04 February 2021

SSD 10447 – TOMAGO RESOURCE RECOVERY FACILITY AND TRUCK DEPOT, 21D AND 21F SCHOOL DRIVE TOMAGO

TfNSW response & requirements

Figure 2-6: Indicative location of Tomago Interchange on M1 Pacific Motorway extension to Raymond Terrace (Source TfNSW Community Consultation October 2020)

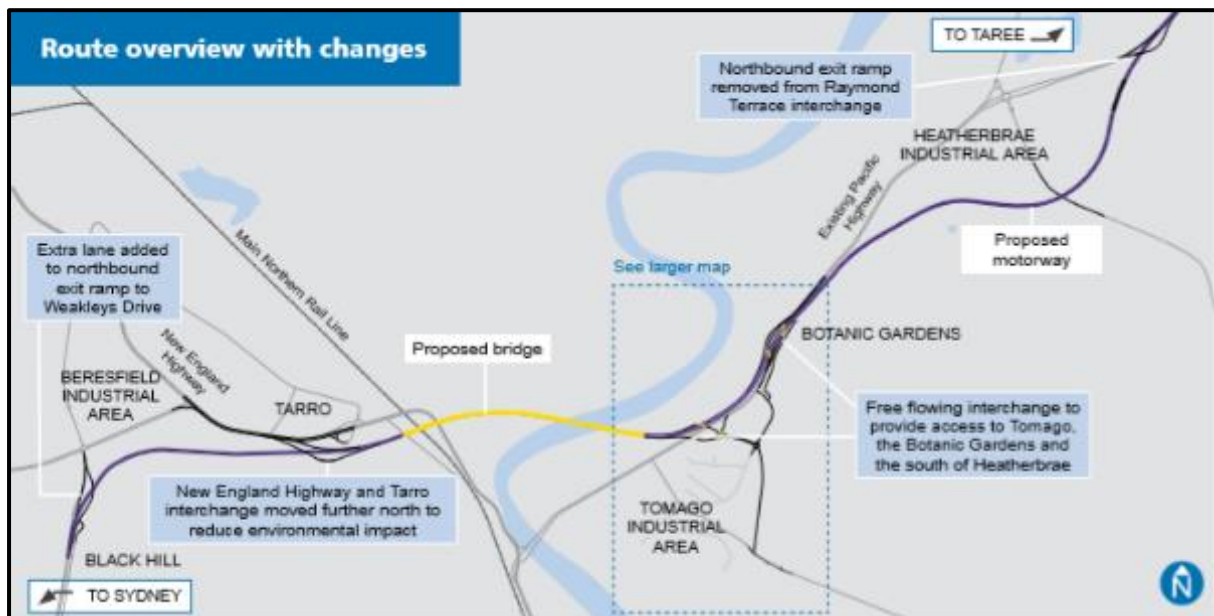
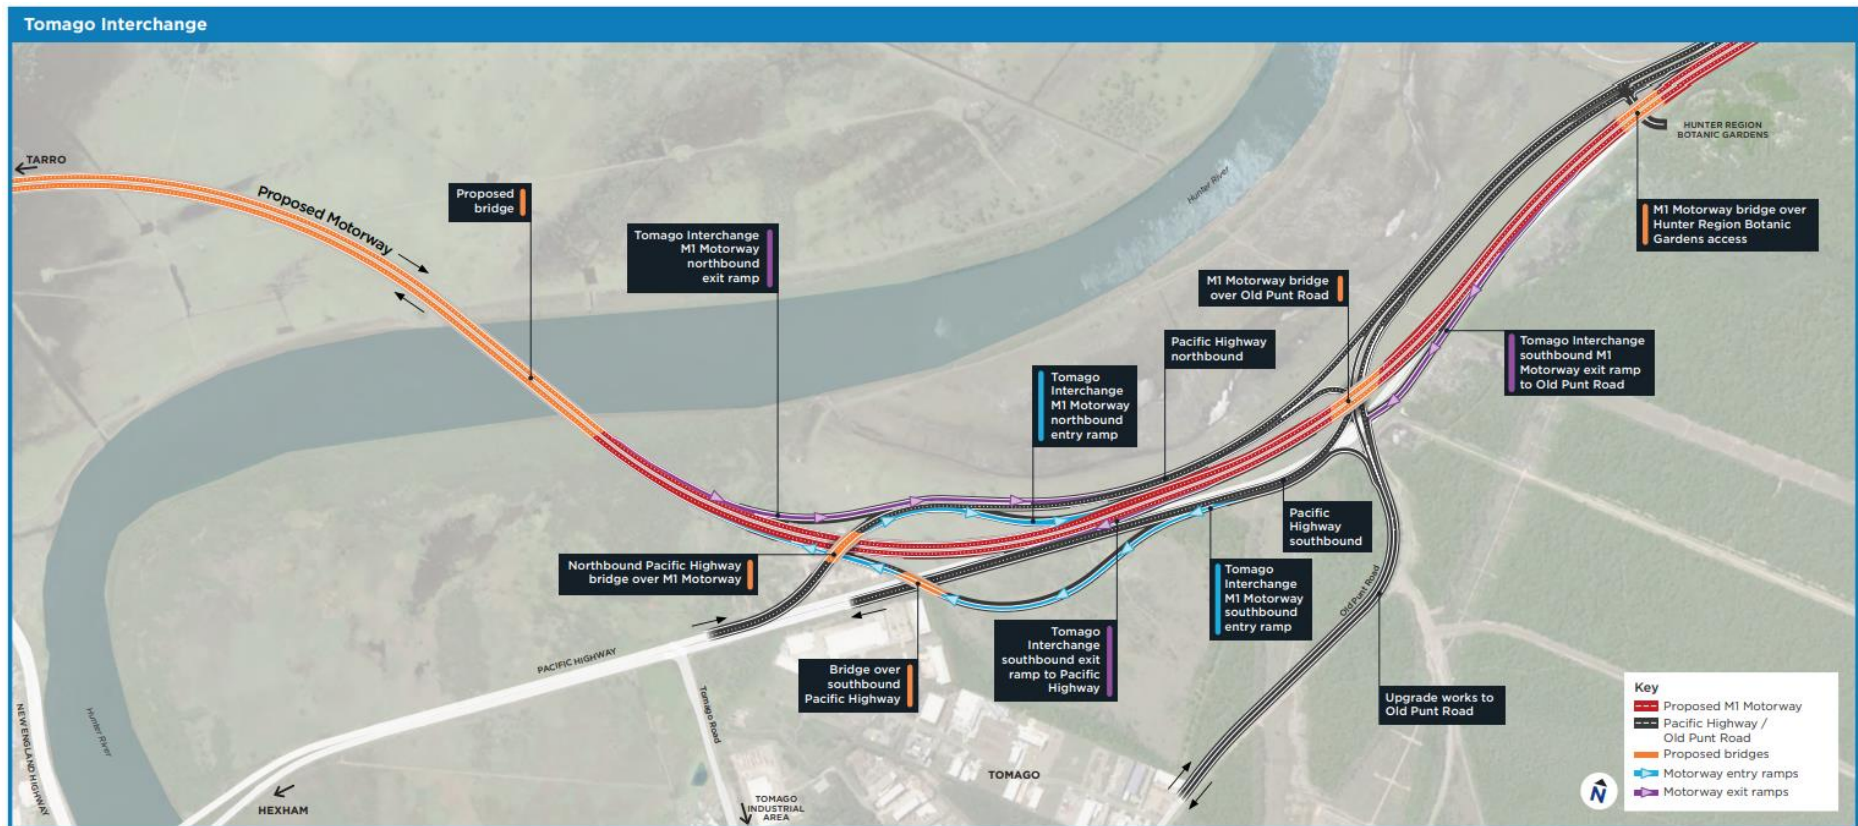
- The current concept design for M12RT is shown in figure 2.6 of Appendix H of the Environmental Impact Statement (EIS). It shows that there has been changes since 2017 (figure 2.5) in the Tomago area. It is noted there no longer a link/bypass road between Old Punt Road and Tomago Road as shown in figure 2.5.
- Commentary in the EIS about reduced demand on Tomago Rd/Old Punt Rd intersection post M1 to Raymond Terrace (M12RT) is to be corrected. Access from Tomago Road to

the M12RT north and south (and Pacific Highway north) is via Old Punt Road using the existing intersection at Old Punt Road/Tomago Road.

Figure 2-10 - PM peak traffic demands, intersection of McIntyre Road and Tomago Road

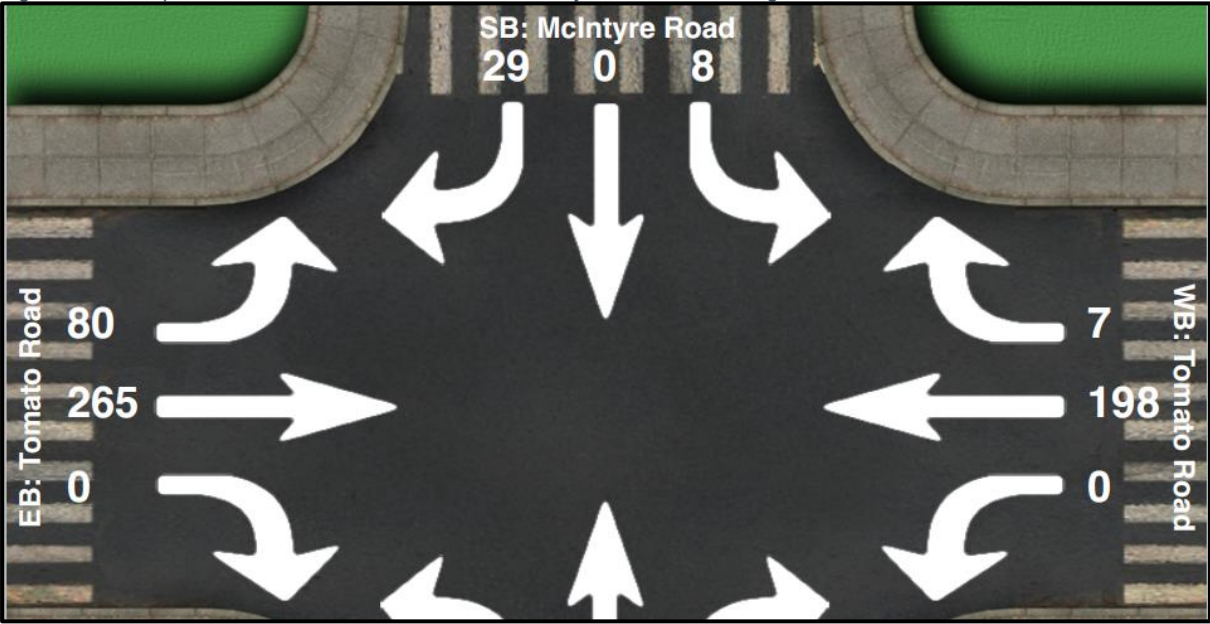
SIDRA modelling of McIntyre Road/Tomago Road intersection suggested LOS E for a right hand turn from McIntyre Road with queue length of 23.5 metres. Note that this may create a potential traffic flow issue due to the short distance of approximately 26 metres on McIntyre Road between Tomago Road and School Drive, there, modelling of School Drive/McIntyre Road would provide the queue length on School Drive. Treatments such as road markings and signs should be considered to ensure that the right turn from McIntyre Road into School road is not blocked by queuing vehicles.
